Site Plan Control Revision

2085 Carling Avenue – Carlingwood Shopping Centre

March 9, 2026

Response to pre-consultation comments

drawing number / No. du dessin
L1

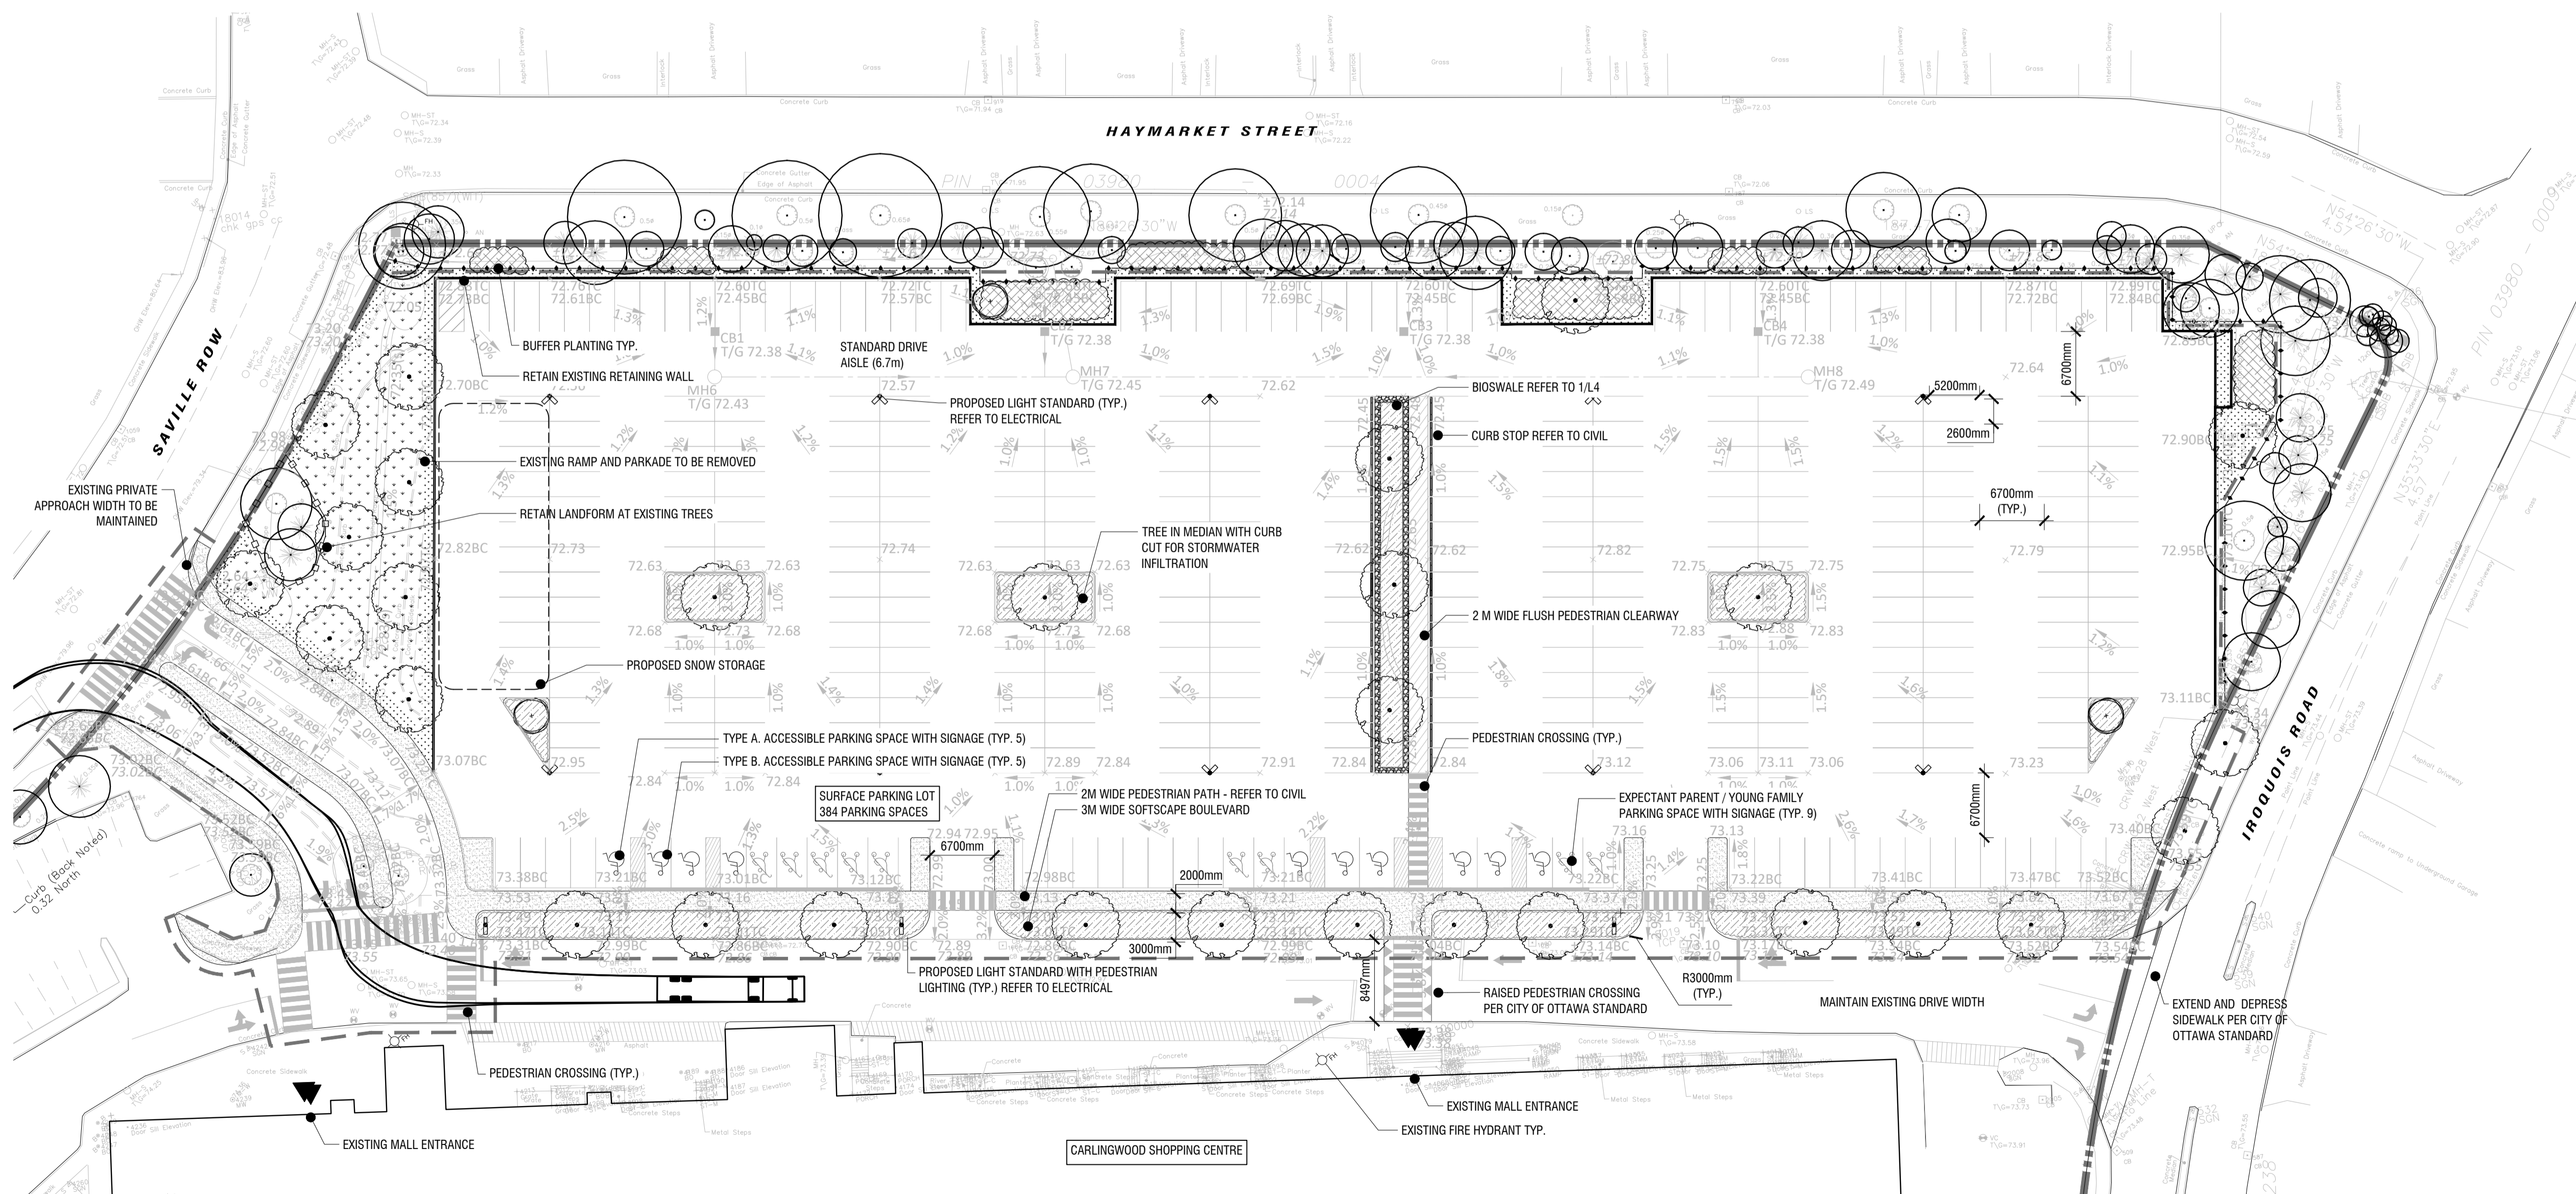
2. Please consider including walking areas to improve safe travel of pedestrians through the parking lot to the entrance.
Pedestrian movements have been considered for the proposed plan.

9. Extend and depress the sidewalk through the unsignalized private approach on Iroquois
Sidewalk has been provided.
10. A TIA is not required for the parking reduction
Noted.
11. Provide corner triangles at the two Haymarket intersections: 3x3 (Iroquois) and 3x9 (Saville)
Corner triangles have been provided.

L2

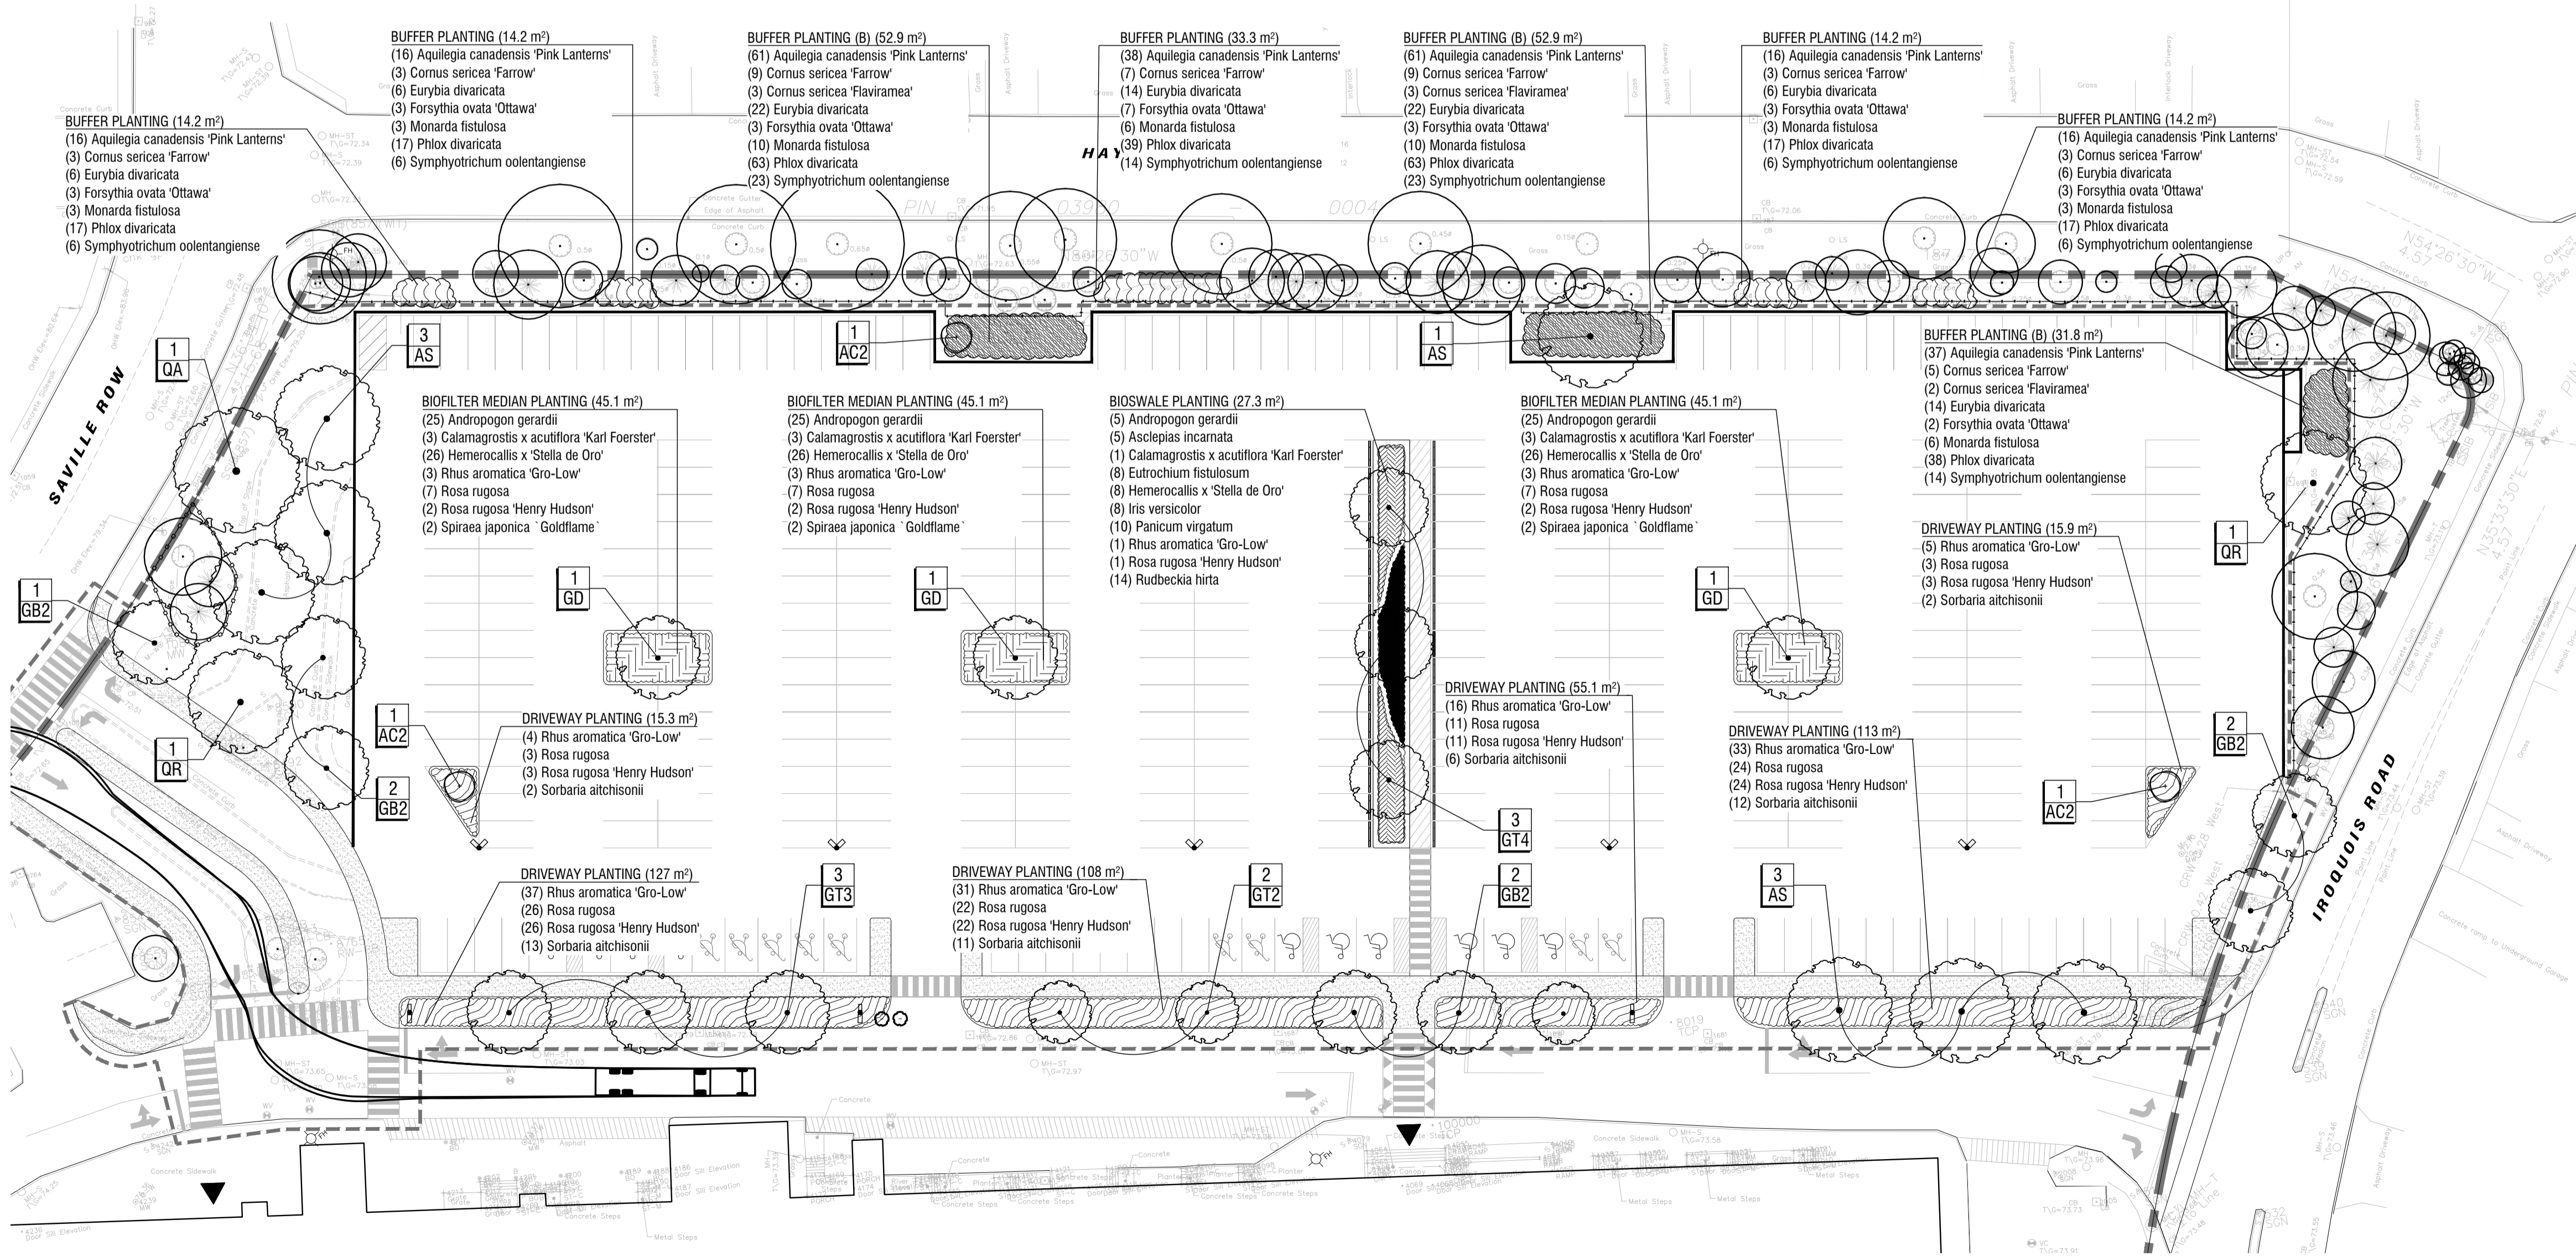
5. We would ask that you introduce further plantings to the Haymarket Street side, buffer the parking from the homes along Haymarket Street. And protect existing trees from being impacted.
Please see attached landscape plan and TCR for tree planting details. Existing buffering is very good due to the existing berm and trees, and the proposed development presents an improvement as the parking lot will be lower than the existing parking structure.
